## Connah's Quay Low Carbon Power

# Draft Statement of Common Ground between Uniper UK Limited and Natural Resources Wales

Document Reference: EN010166/8.2

Revision 02

Plate 3: Curlew records (2023/2024) within the Main Development Area

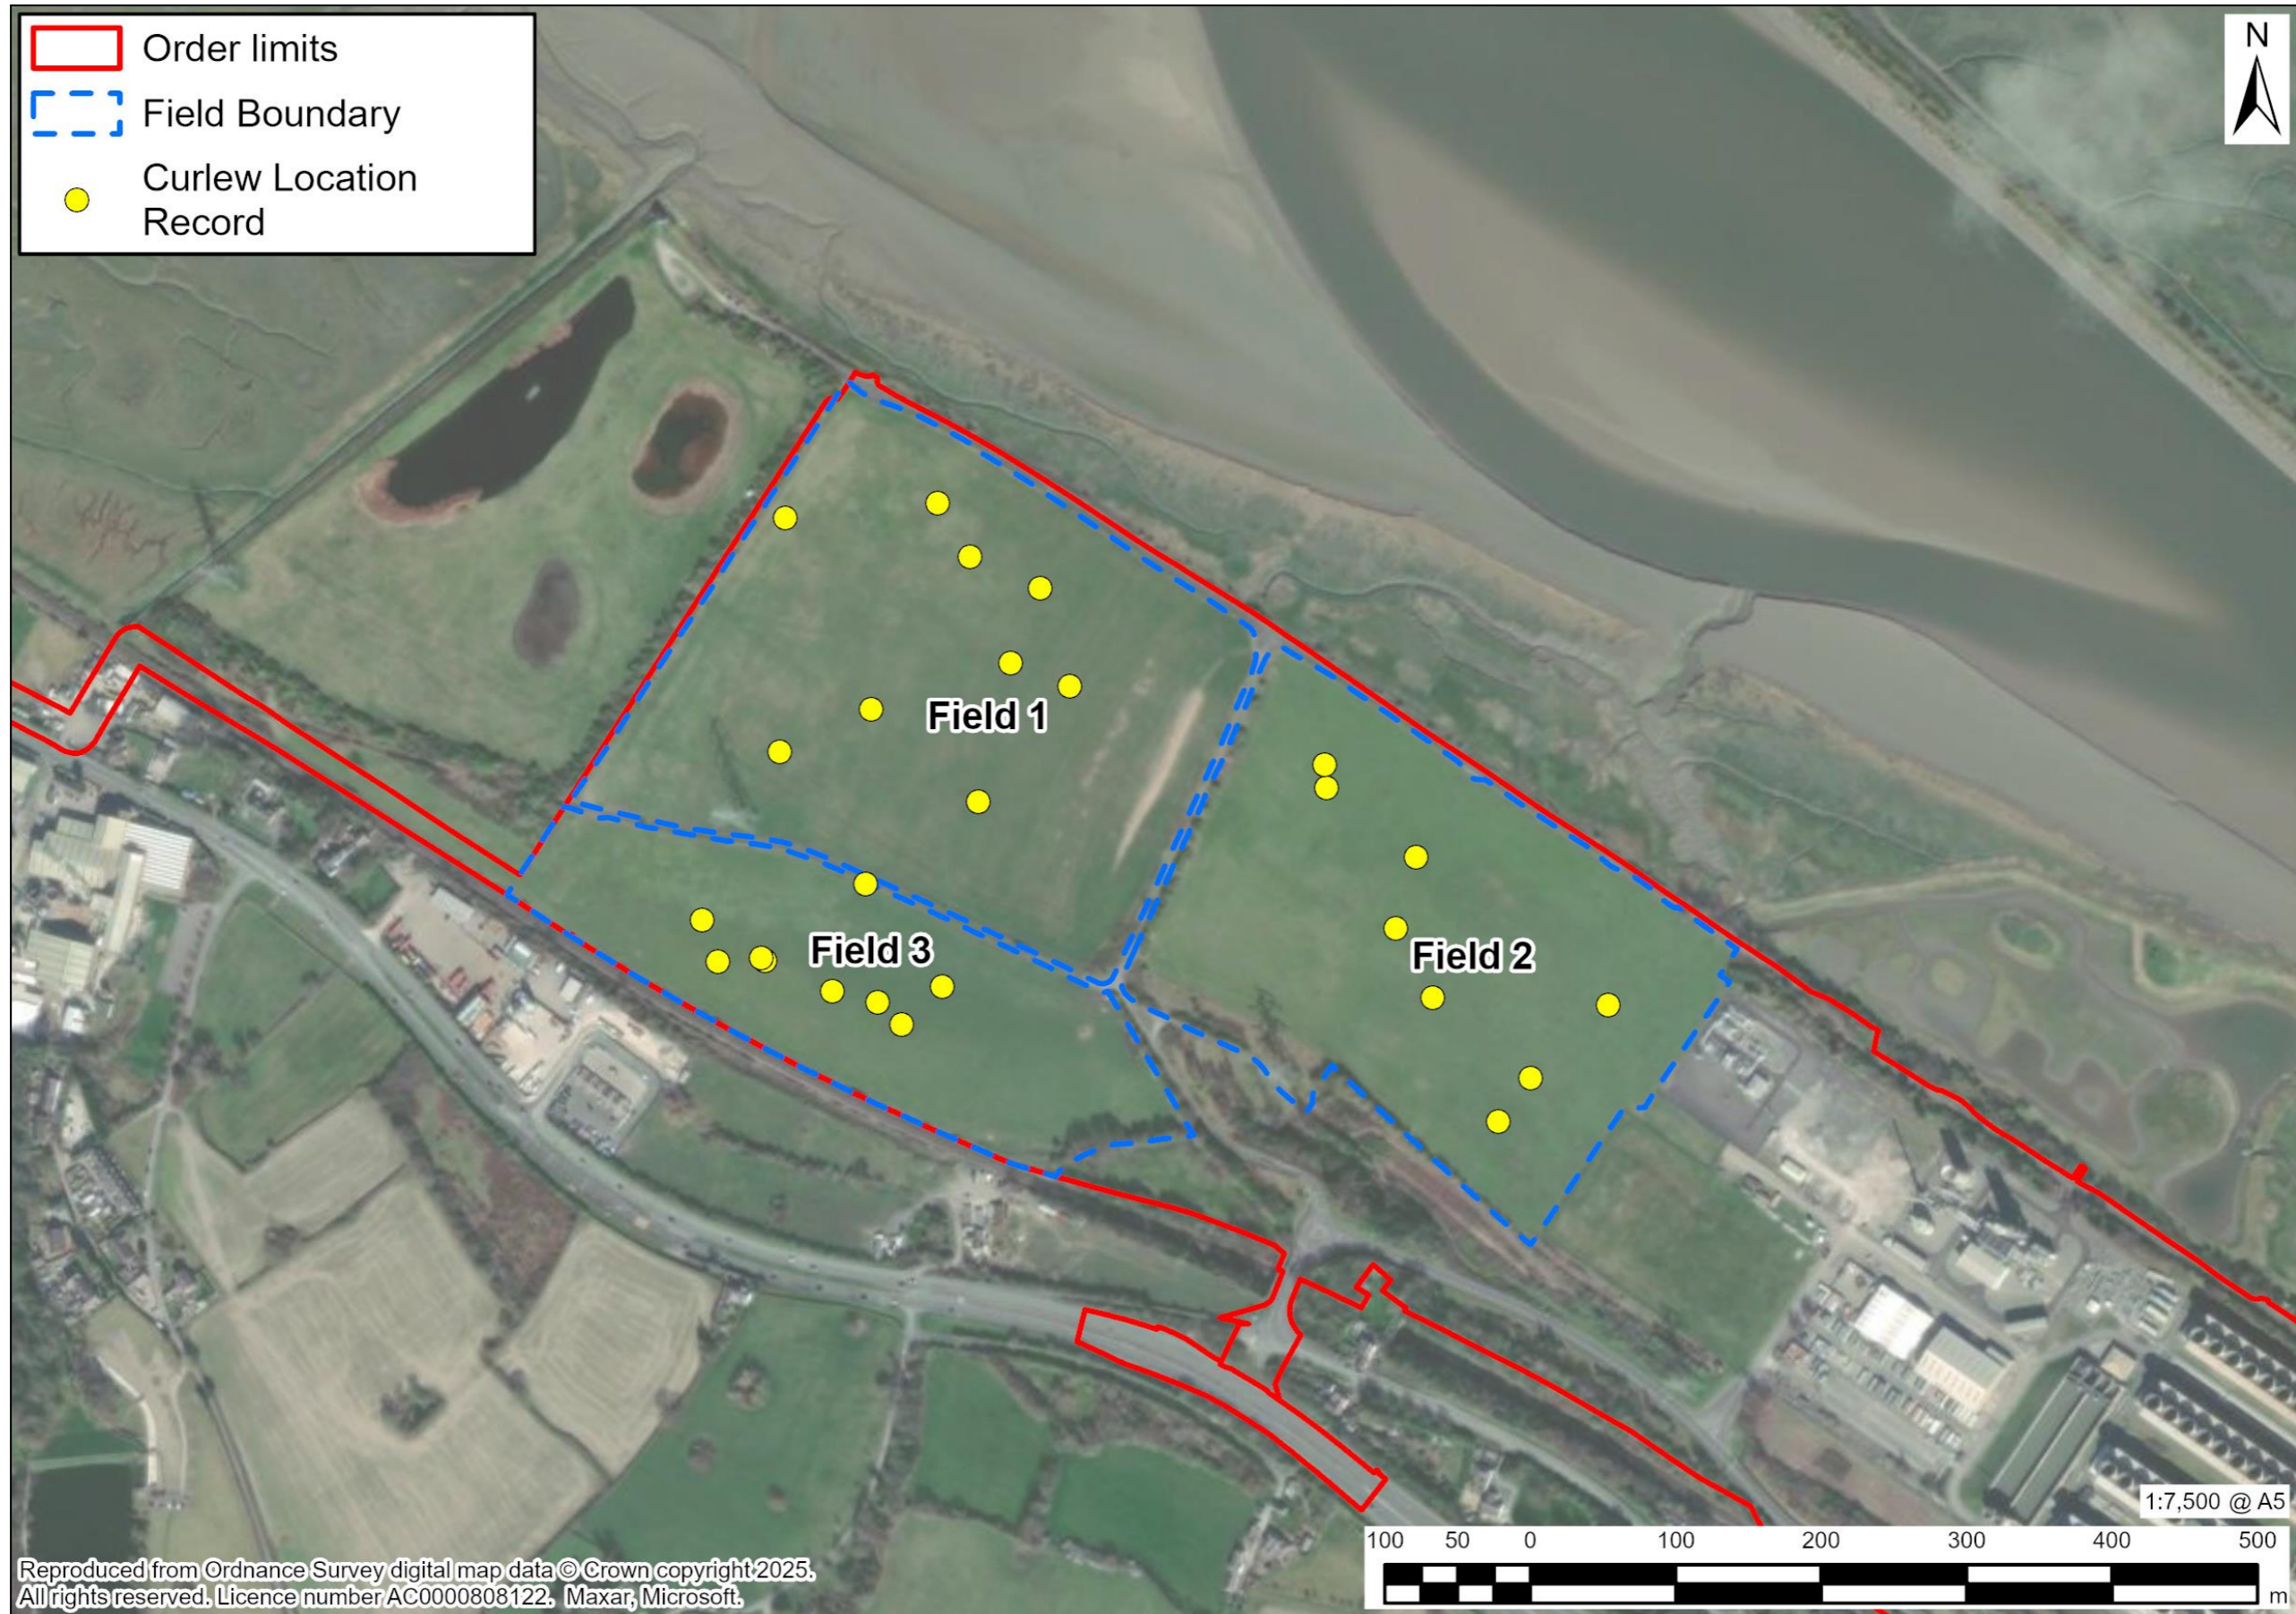
NRW 10	Curlew Mitigation Strategy	<b>Curlew Mitigation Strategy [APP-254]</b>	<p>We also advise that the following clarifications and details should be provided for the CMS:</p> <p>1) Para. 2.4.2: Table 1 does not include historic data, only covers one year, and is likely to be too narrow in the range of months when curlew are found in significant numbers at the site. Historic data held by the applicant and Deeside Naturalists' Society (DNS) should be referred to as these may show a greater range of months when significant numbers of curlew, and possibly other qualifying species, occur within the affected fields (i.e. August, September and October). Historic data may also provide longer-term trends in the numbers of curlew (and other bird features) using the Functionally Linked Land. This may be important when determining the effectiveness of management measures in the proposed offsetting land i.e. historic baseline curlew numbers in offsetting land versus curlew numbers in preferentially managed land.</p>	<p>The points are addressed in turn.</p> <p>1) This is noted. The Applicant will continue to engage with the Deeside Naturalists' Society (DNS) and NRW on availability of existing data sets.</p> <p>2) The Applicant is in the process of commencing groundwater monitoring to inform future management. The Applicant will continue to engage with NRW on groundwater monitoring and provide NRW with any feedback of results.</p> <p>3) The Applicant is currently undertaking further non-breeding bird surveys of the mitigation area and will continue to engage with NRW on results of these.</p> <p>(4 – 9) These points are noted and the Applicant will continue to engage with NRW on the <b>Curlew Mitigation Strategy [APP-254]</b> and submit an updated version of this strategy at an appropriate point during the examination.</p>	<p>The parties continue to discuss the <b>Curlew Mitigation Strategy [APP-254]</b> and have arranged a meeting on site on the 18<sup>th</sup> March 2026</p>	Under discussion
